Recommendation Report for Planning Permission for Works or Extension to a Dwelling

REF NO: AW/158/21/HH

LOCATION: 11 Merton Close
Aldwick
PO21 5SQ

PROPOSAL: Replace front and rear tile facade with concrete fibreboard cladding.

Existing North-East Elevation

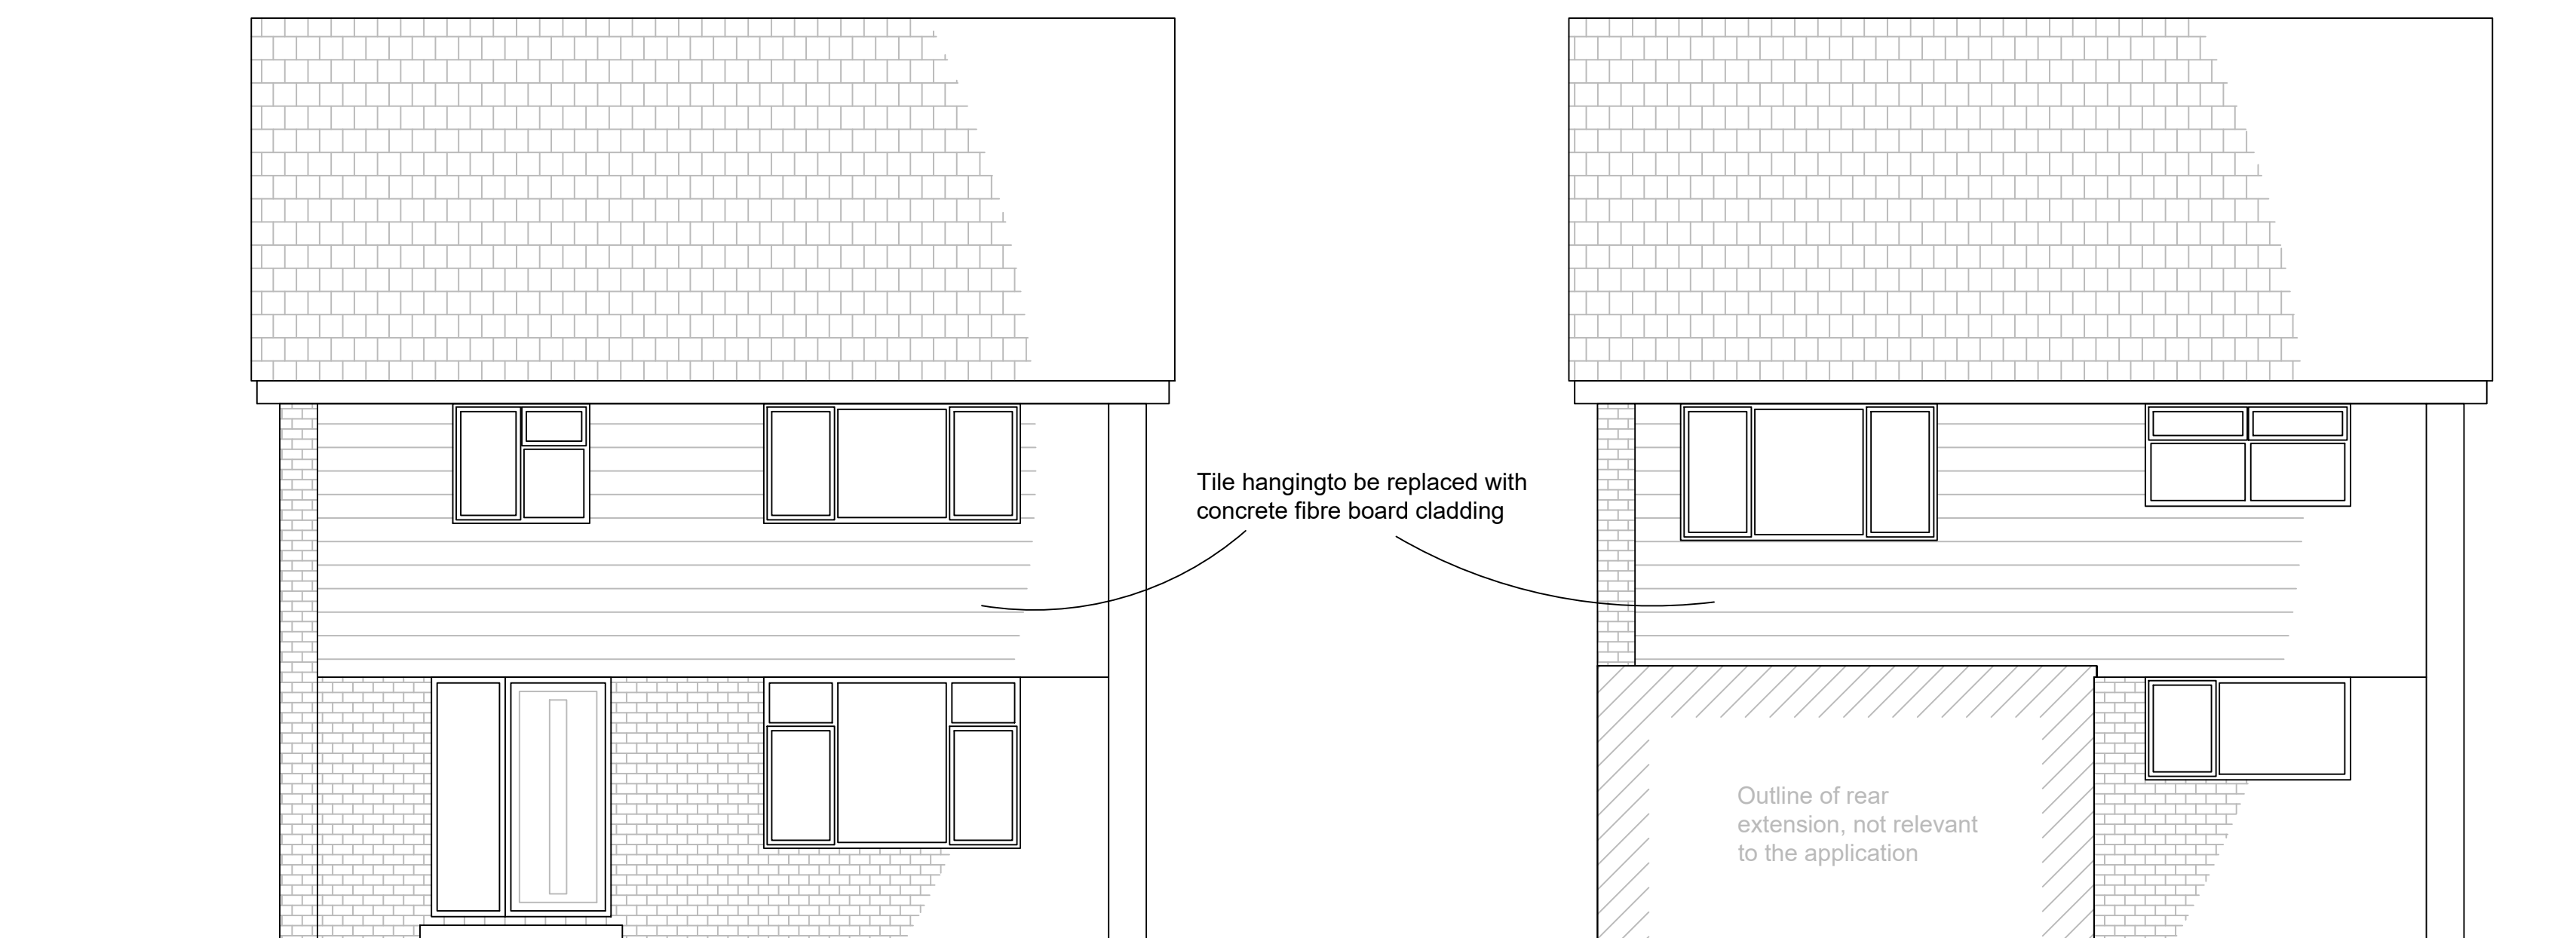
This application does not seek any additions to the properties size, scale or amount, and only looks to alter the external materials. The proposals are to replace front (north east) and rear (south west) brick red tile facade overhangs to first floor with concrete fibreboard cladding in an unspecified grey colour. Due to the siting of the proposals at the front and rear of property the proposal will be highly visible from the street scene. Whilst the change in materials from a red tile facade to a concrete fibreboard cladding in grey colour is not-in keeping with the design and materials of surrounding properties, which all have a red tile facade, the concrete fibreboard cladding in a grey colour will not cause adverse effects on street scene and will not lead to adverse harm on surrounding character of area so will comply with policy D DM1/D DM4 of the Arun Local Plan.

Whilst the materials used don't match the property and character of area, the use of concrete fibreboard cladding in a grey colour will not adversely impact the character of surrounding area so is acceptable.
